**Planning Application: 3/2021/0311**

**Proposal to demolish and convert a number of agricultural buildings at Brockhall Farm, into 8 residential properties; construct a number of garages for the use of the residents; and redevelop the surrounding landscaping to incorporate parking, landscaping and amenity spaces for each property. Resubmission of 3/2020/0180. Brockhall Farm, Brockhall Village, Old Langho**

The current application is accompanied by Oxford Archaeology North's 2021 *Archaeological Desk-Based Assessment and Historic Building Survey*.

Plate 5: Brockhall Farm 'as existing' prior the construction of the hospital farm buildings, held by Mr. Willan. To aid legibility of the descriptions, north is down

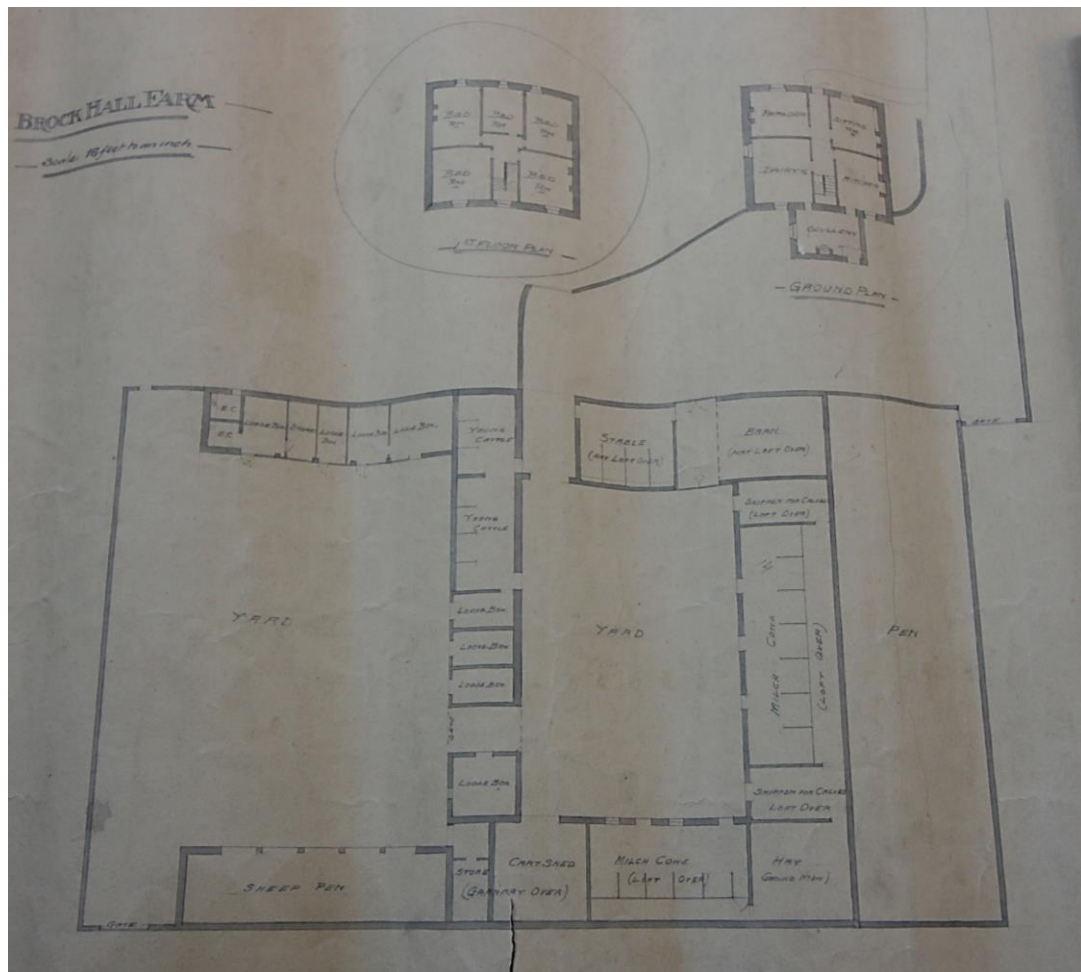
2. The source for Plates 3, 4 & 5 needs to be clearly stated. These maps can be viewed on [Lancashire County Council: Environment Directorate: Old Maps](#), which has been included as a source in the Bibliography. Such use of material from the Lancashire County Council Old Maps web-page is not permitted. There is a quite clear statement to this affect in the section "Notes" on the web-page, which includes the following:

"There is no objection to using these maps for personal research but they cannot be reproduced elsewhere including within planning applications or their supporting documentation",
